From: Sue Howell
Sent: 06 December 2017 15:15
To: Planning.Responses
Cc: Simon Davis
Subject: RE: Please find attached amendment on planning application Ref: Y/40/17/OUT

Comment from Greenspace

APPLICATION NO: Y/40/17/OUT

Grid Reference:**Category:** Plan Applicat'n**Description of Works:** Outline application with some matters reserved (access only) for the erection of 23 No. dwellings with access from Hoe Lane, Flansham. This application is a Departure from the Development Plan.

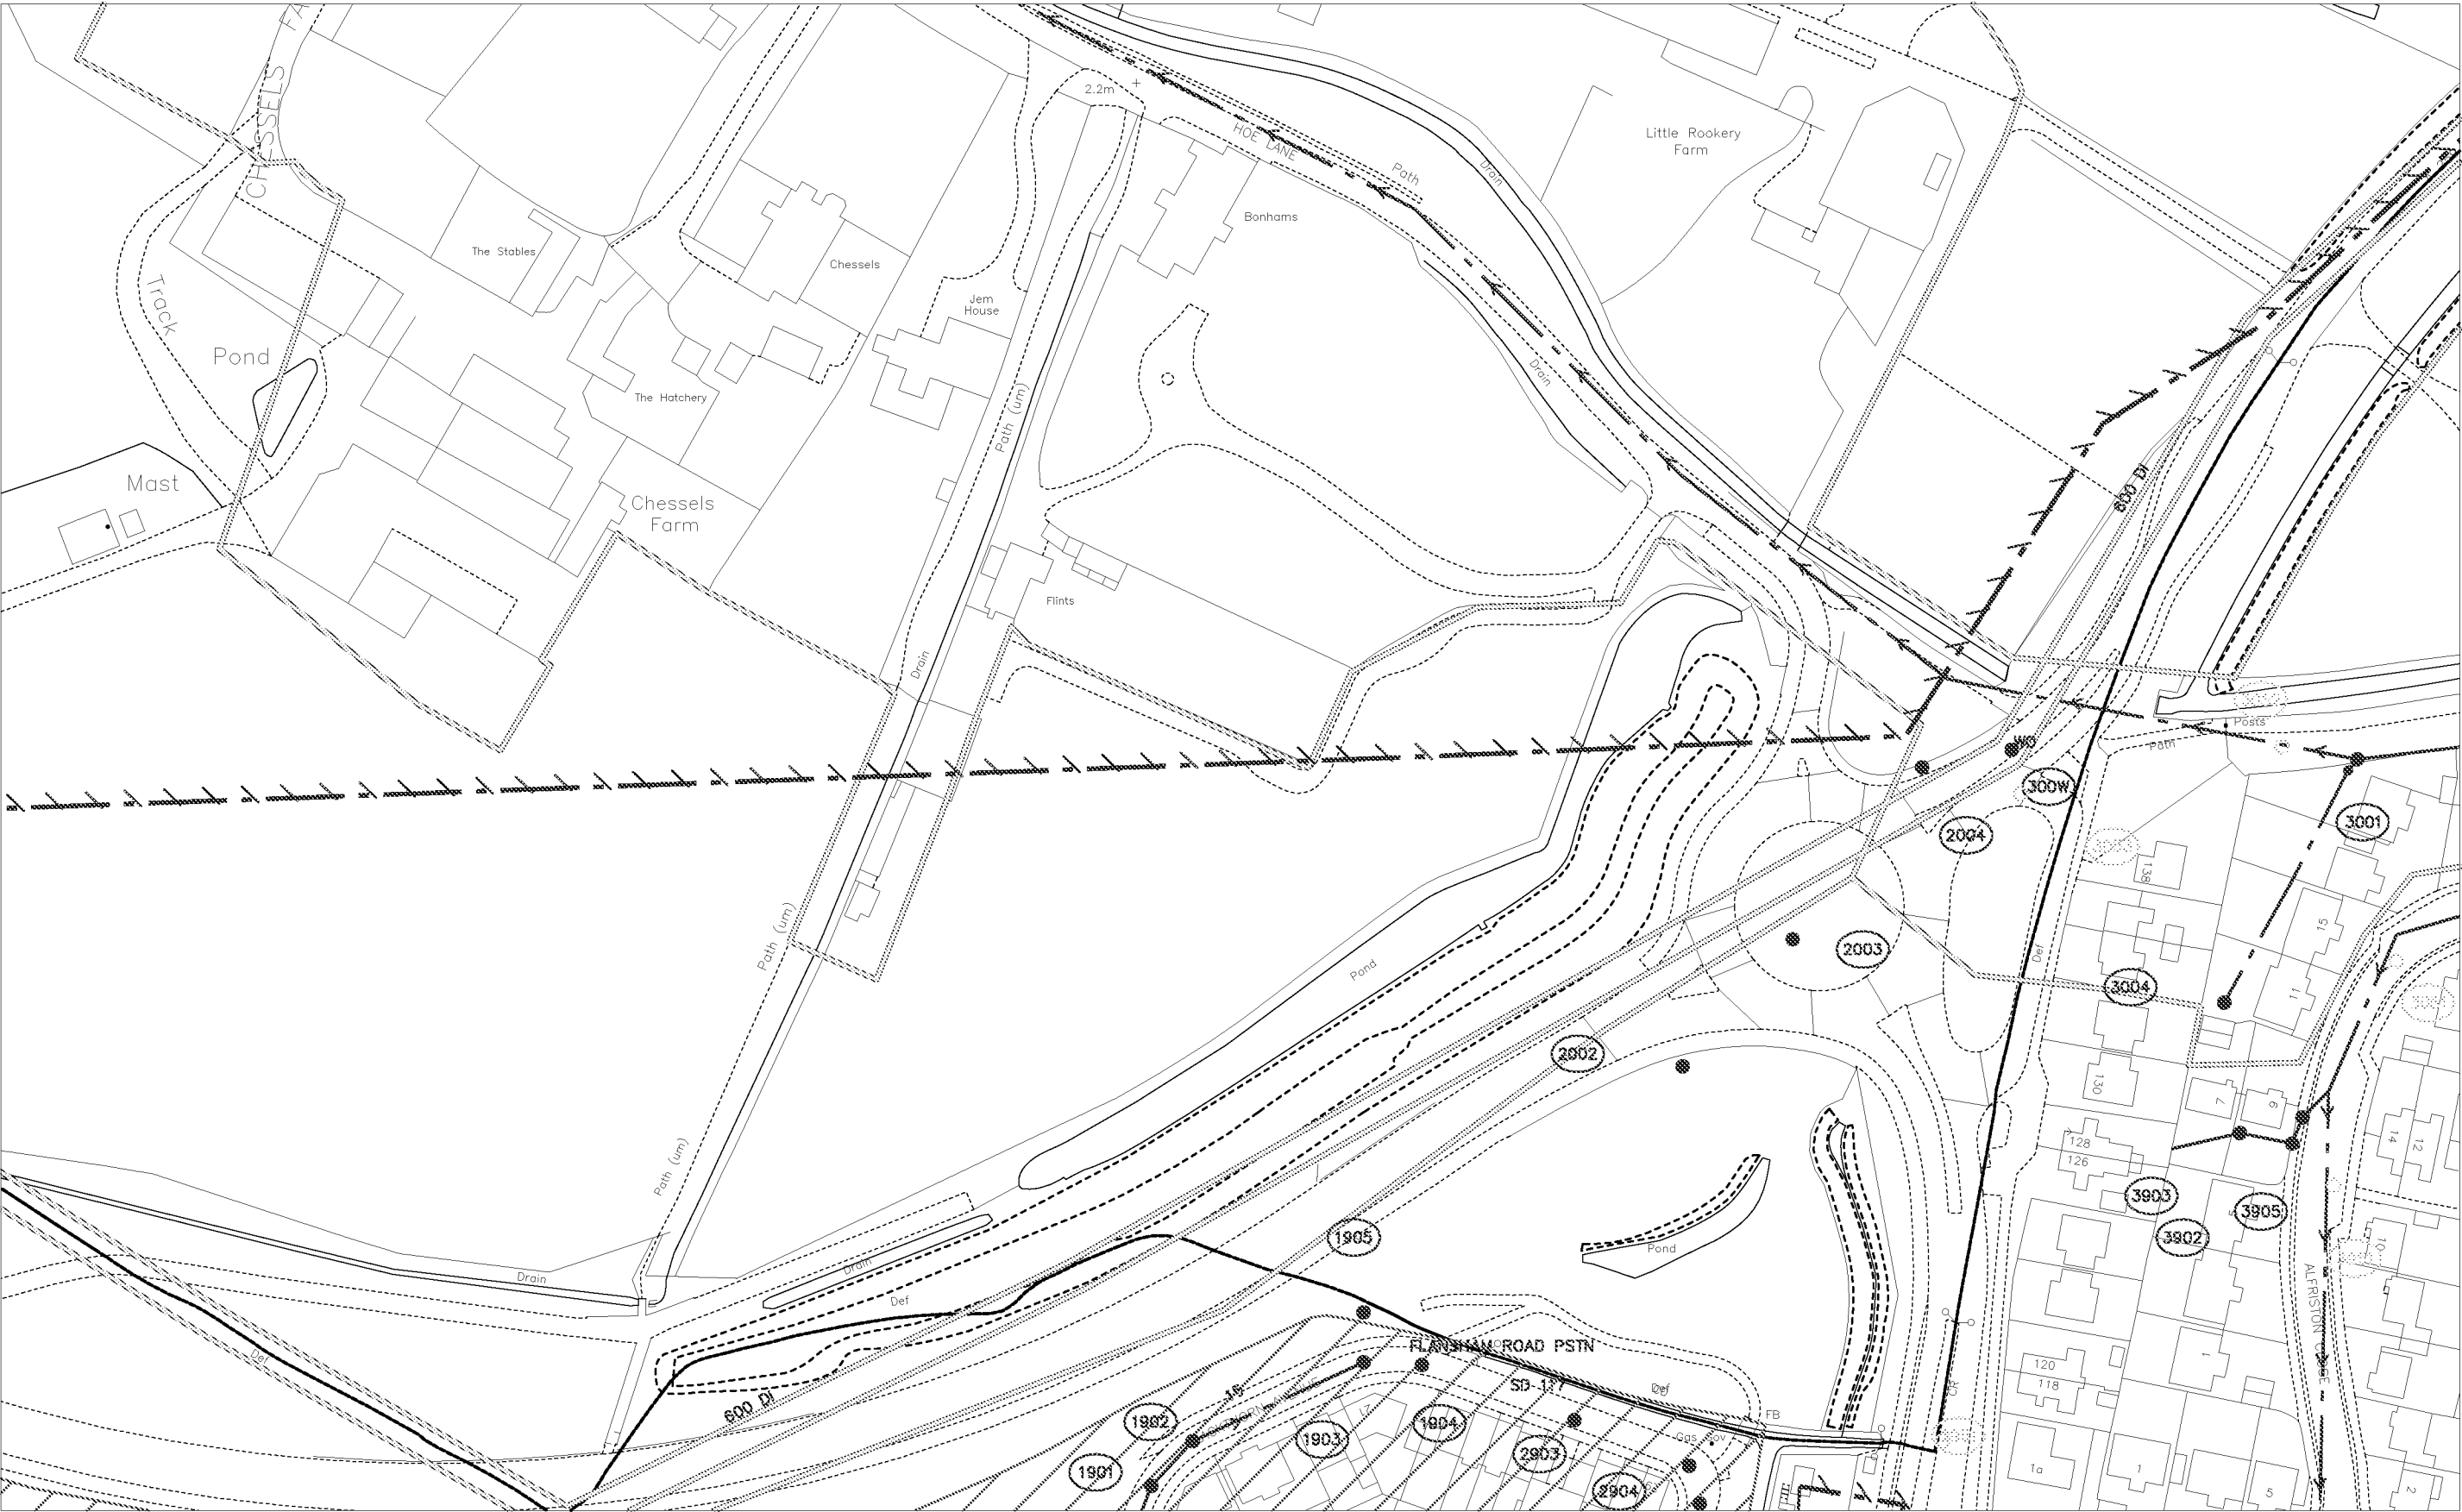
The reduction of units from 34 to 23 is much more fitting for the site, which now accommodates the existing worthy trees in a far more sympathetic way. Good to see the open space placed centrally within the site much more beneficial to the whole development. Regarding the play, because of the proximity to Flansham Lane POS and Flansham Lane rec then a LAP will be sufficient for this application. I would however recommend this is located within the central POS area rather than in the southern corner location by the parking bays as presently shown. As LAPs are unequipped, but offering natural play experience then this would not be expected to contain formal play equipment but rather play experiences in the form of mounds/boulders/logs etc.

I therefore confirm I would recommend no objection now to the amended application dated 27 November 2017, on landscape grounds, to the revised detail submitted under Y/40/17/OUT.
